Update title to match
the rest of the
application.
"Struthers Ranch
Subdivision Filing No.
5

Struthers Ranch Tract B Traffic Impact Study (LSC #204110) January 8, 2021

Please add the
following: "PCD File
No. VR-2101"

RE: **Struthers Ranch Tract B**
Traffic Impact Study
El Paso County, Colorado
LSC #204110

Figure 2
Site Plan

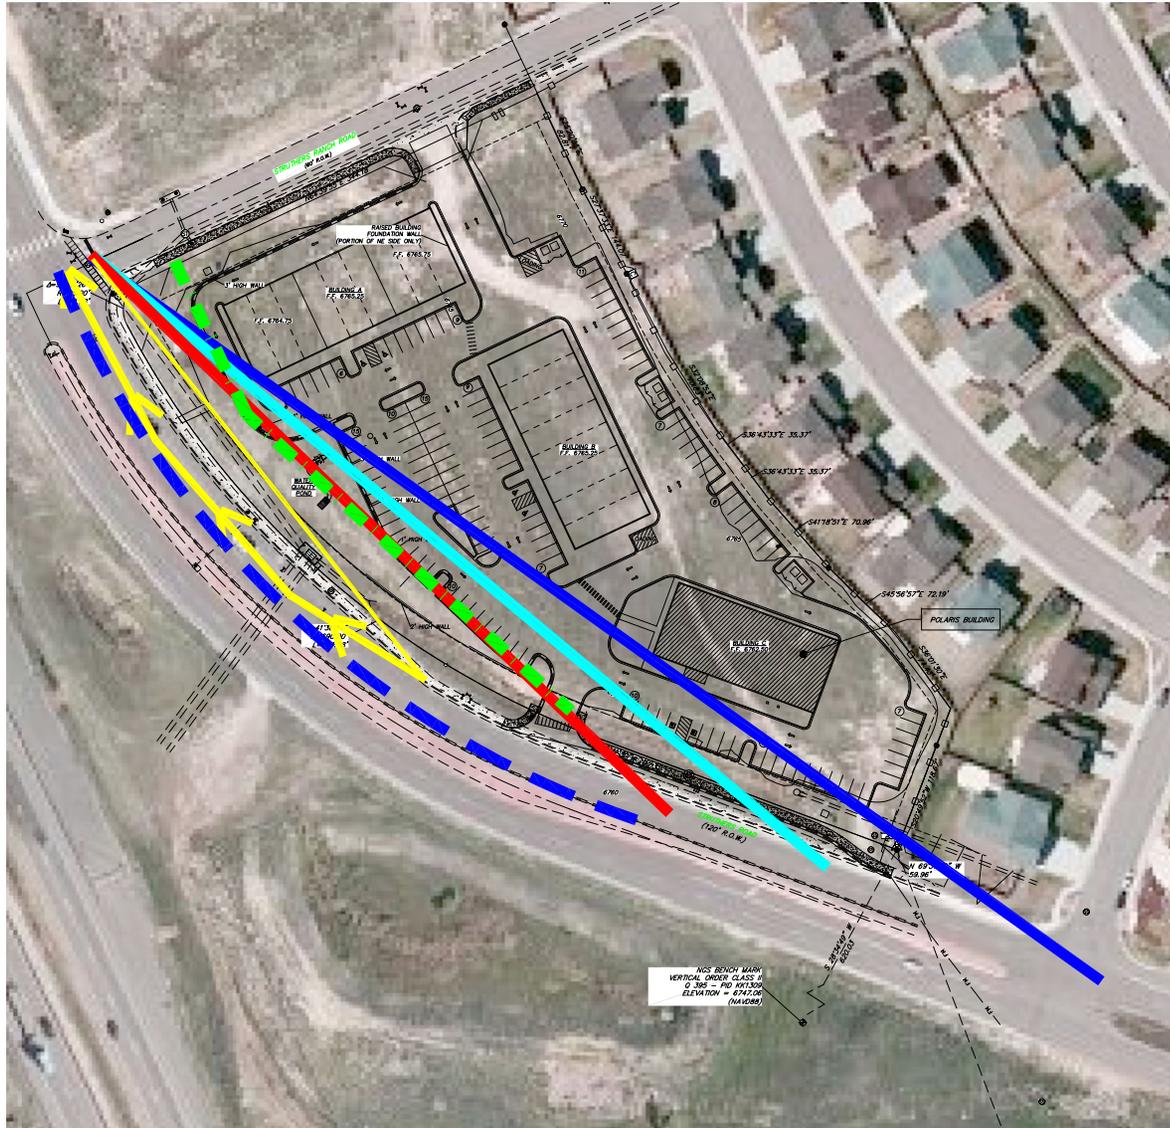
Discuss this deviation request with your client. Staff does not see an undue hardship to justify a deviation request for access on Struthers Road. With access available at Struthers Ranch Rd, this deviation request will likely be denied.

If the request is withdrawn then update the TIS analysis based on a single access from Struthers Ranch Road.

Please note: If the applicant chooses to pursue the request, staff encourages you to submit the deviation request form prior to the 2nd resubmittal. The determination to approve or deny the deviation impacts the traffic report.

Exhibit 2
**Line of Sight for
 Intersection Sight Distance
 (Struthers Ranch Rd to/from the south)**

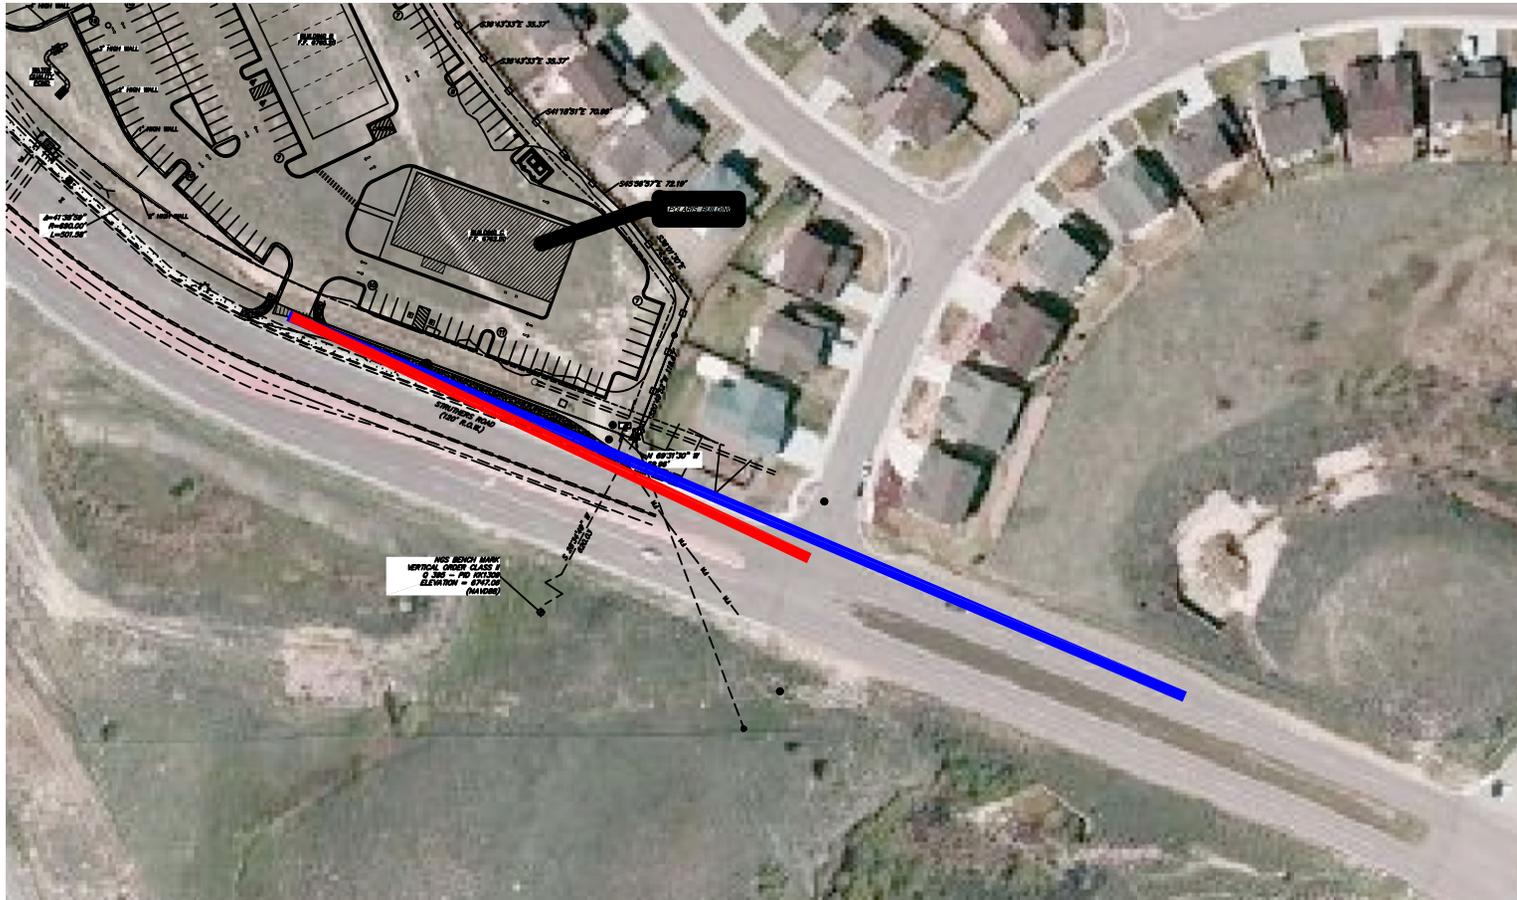
Please revise 18 inches to 30 inches above the flow line of the adjacent road per ECM 2.3.6.G.2.

Update the required intersection sight distance and update Exhibit 1. Intersection sight distance applies to Struthers Road/Struthers Ranch Road intersection.

Intersection sight distance is ECM 2.3.6.G Table 2-21.
Driveway access sight distance is ECM 2.4.1.D.
